OXFORDSHIRE COUNTY COUNCIL'S RESPONSE TO CONSULTATION ON THE FOLLOWING DEVELOPMENT PROPOSAL

Application no: 17/00610/REM

Proposal: Reserved Matters to Approval 10/01642/OUT - Access for Camp Road Village Centre Highway Infrastructure Works. The original outline application was accompanied by an Environmental Statement.

Location: Heyford Park, Camp Road, Upper Heyford, Bicester OX25 5HD.

DETAILS VILLAGE CENTRE - S278 SURFACE FINISHES LAYOUT

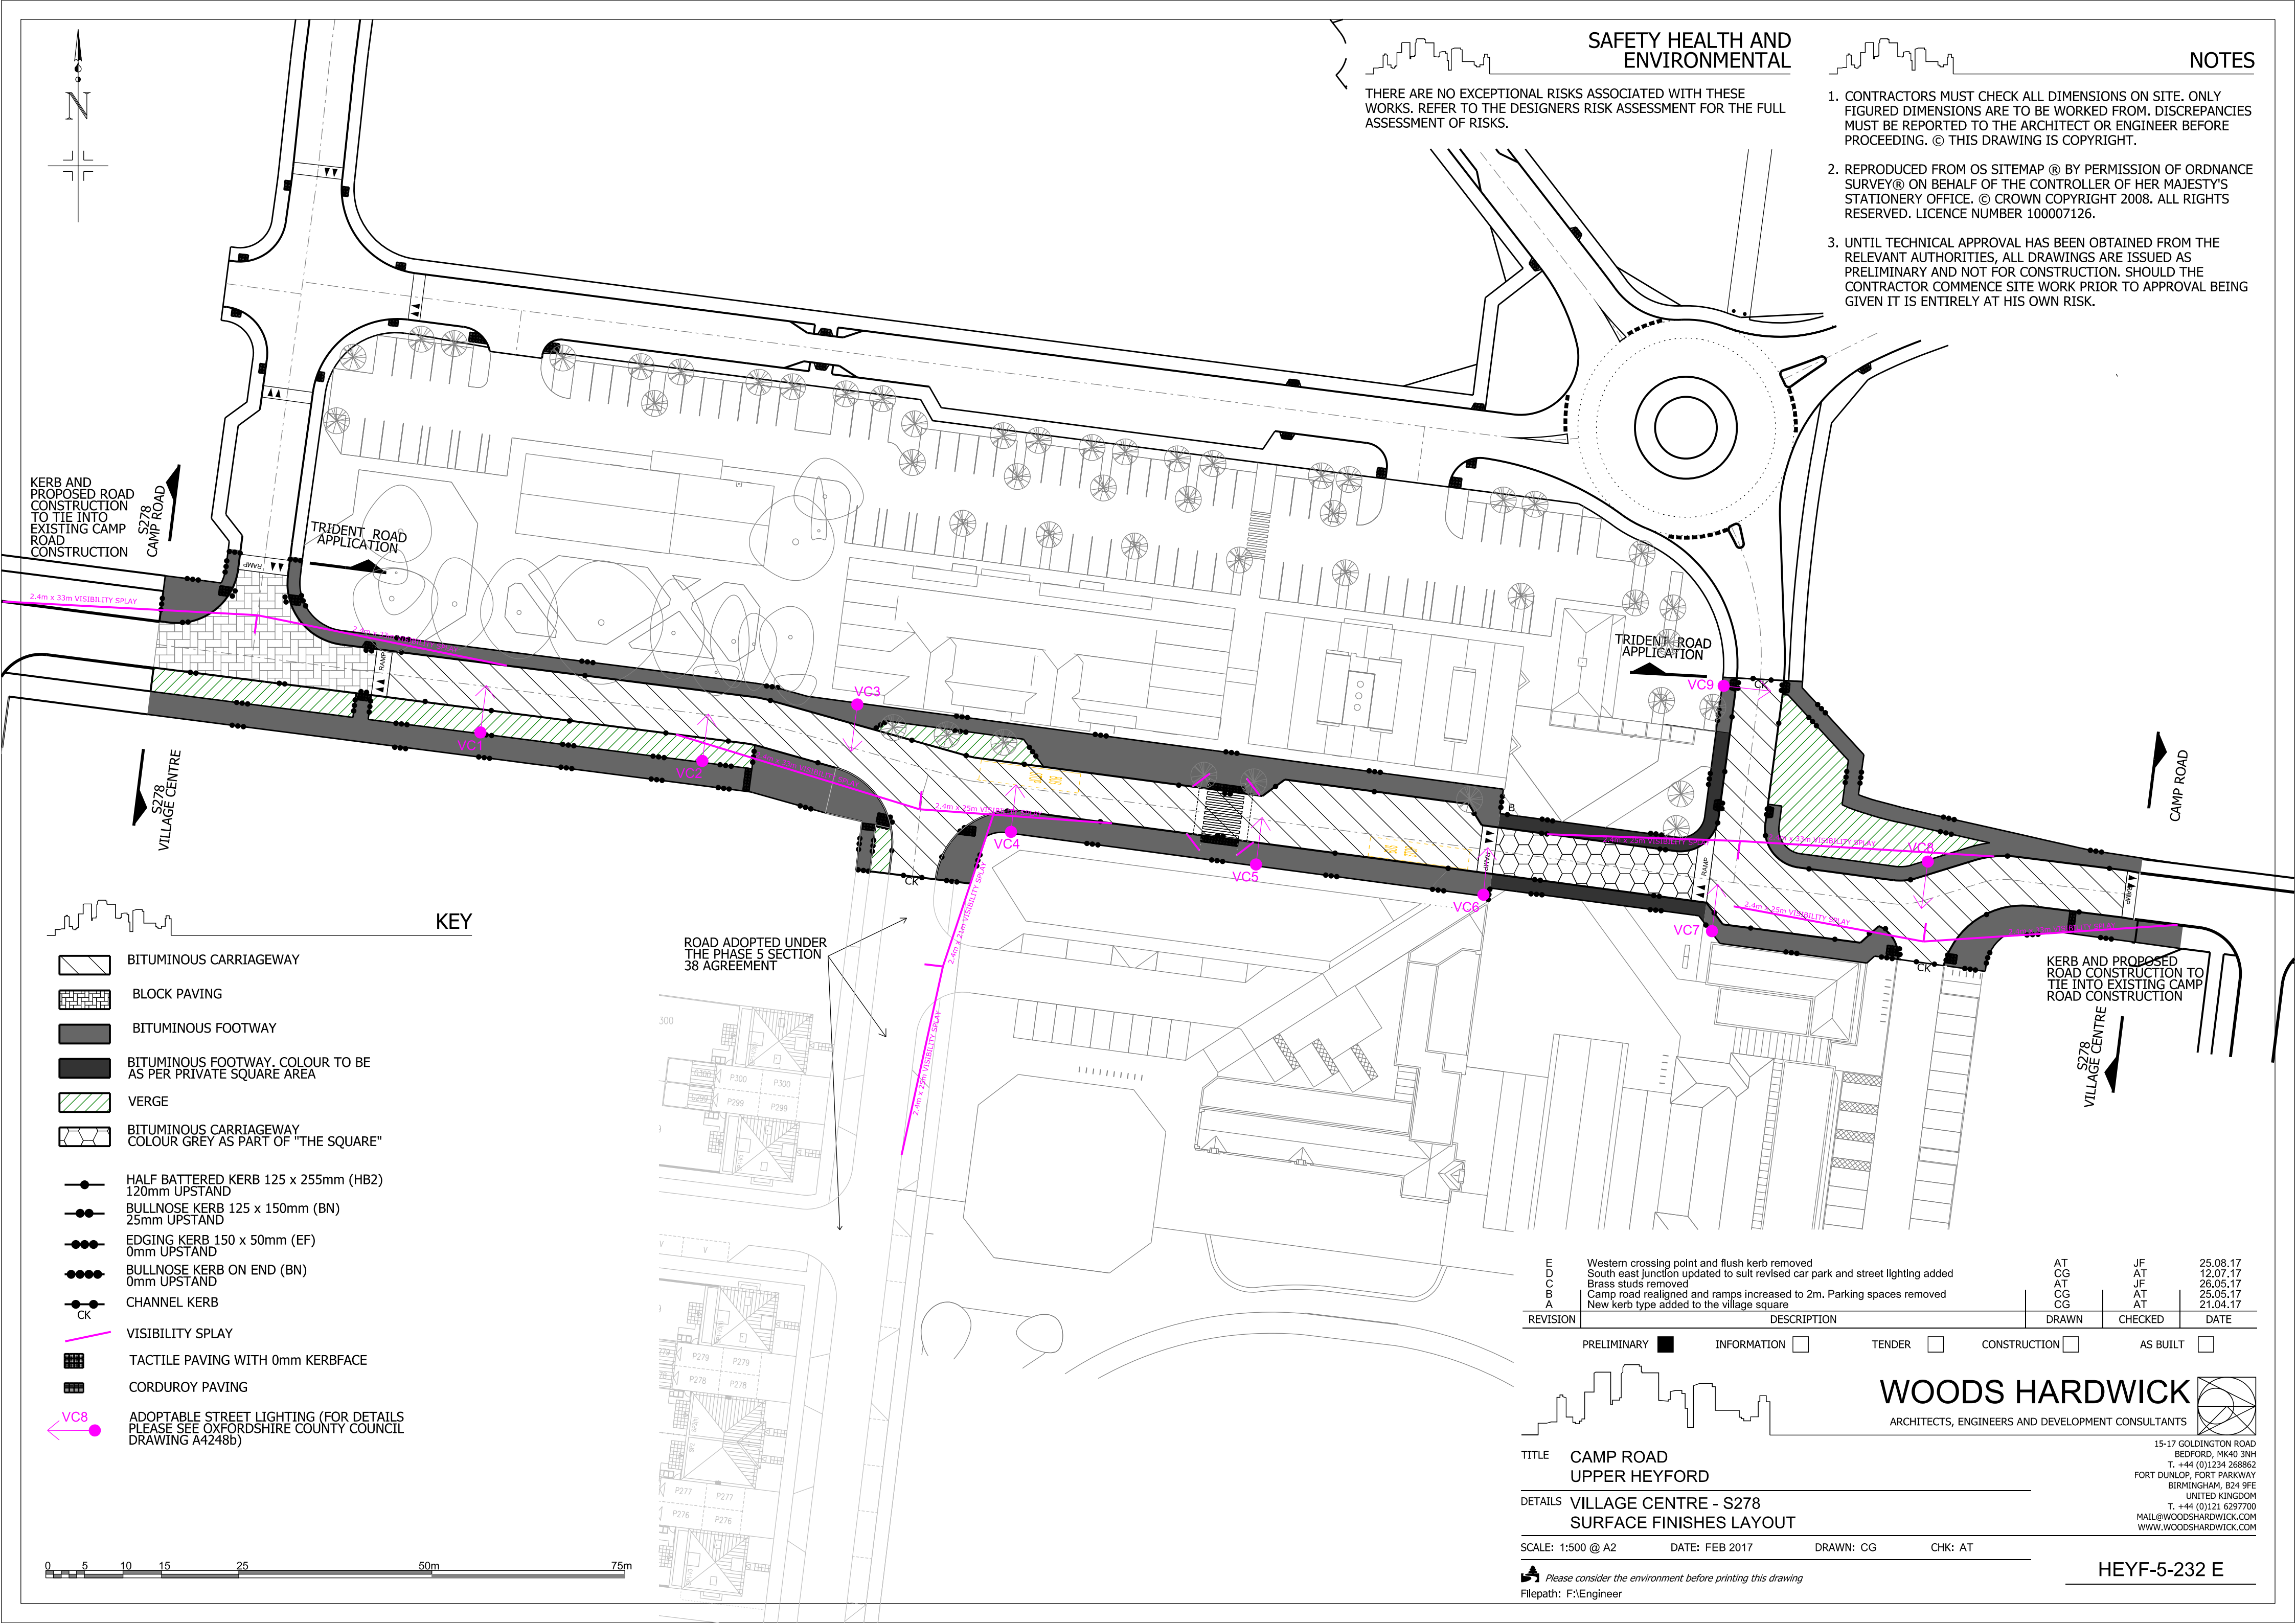
The bus stop locations, particularly the eastbound stop, are not good in respect of the proposed zebra crossing. The crossings and calming measures would require consultation.

- The controlled crossing will require 8 crossing protection zig-zag markings on the approaches and a minimum of 2 on the exits. Parking is prohibited on both sides of the this type of marking.
- Parking bays will need to be moved out of the crossing protection zone.
- Vehicles parked in the Southern parking bay should not obstruct the visibility splay at the southern access junction. As this bay already appears to conflict with the visibility splay,

moving the parking bay further west may not be an option. It may have to be reduced in size.

- Vehicles parked in the northern parking bay may restrict visibility for pedestrians crossing Camp Road at the square.
- Bus stops will need to be moved out of the crossing protection zone.

- Moving the northern Bus stop further west may cause conflict at the Southern access junction.
- It is unclear if, or how, the shared footway/cycleway terminates into footway at the zebra crossing and narrowing around the parking bay.

- It is unclear if, or how, the shared footway/cycleway terminates into the square, which is presumed to be a pedestrian only area due to the width of the proposed highway footway.

- 2.4m x 25m visibility splays rely on low speeds. It is unclear that such low speeds will apply at all times of the day and week.
- The 25mm kerb up-stand through the square would be an obstacle for wheelchair users, and the partially sighted wouldn't necessarily recognise a crossing opportunity. The County would expect to see dropped tactile crossing points across the square.

- The County would expect to see the northern footway continue on the desire line directly across the Trident access and verged area.
- The ramp on the eastern edge of the square may create a safety issue when turning left into the Trident access at speed. This ramp may also cause issues for vehicles turning right out of the access, particularly as there is no kerb up-stand on the square to prevent vehicles mounting the footway.

- Vehicles parked in the southern loading bay, to the east of the square should not obstruct the visibility splay for the access to the hotel car park.

- An additional uncontrolled pedestrian crossing may be required to the west of the controlled crossing, potentially just to the west of the southern access.

- The footway through the square could be constructed out of the same material as the square, and the highway demarcated with brass studs.
- A new, more robust raised table/ramp construction details to be agreed through the S278 technical approval process. It should be noted that OCC will no longer accept block work ramps on Camp Road.
